Subdivision PH Comments

From: Holly Myers, Environmental Health Supervisor

RE: SP-16-00002 McElliott

# McELLIOTT AGRICULTURAL SHORT PLAT PART OF SECTION 20, T. 18 N., R. 19 E., W.M. KITTITAS COUNTY, WASHINGTON

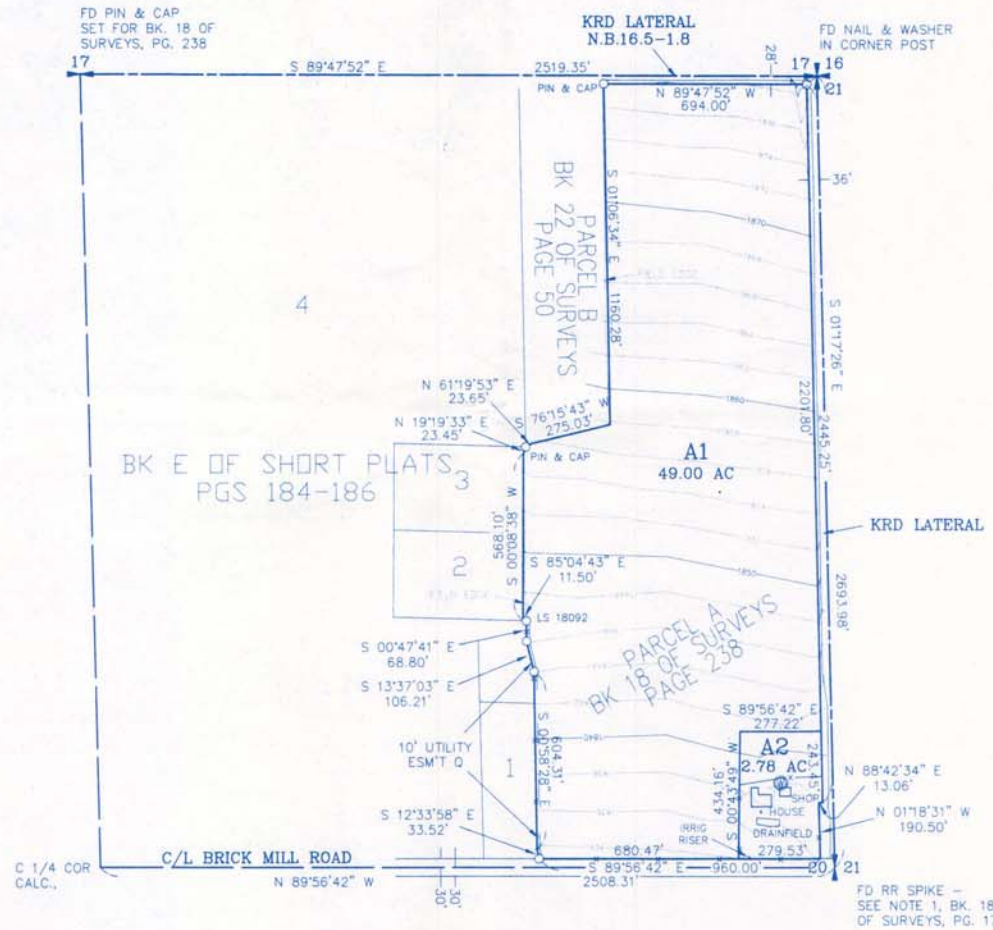
Provide WBN mitigation for lot A-1 as well as a soil log. Provide well logs or shared well users agreement to prove adequate water is available on both lots.
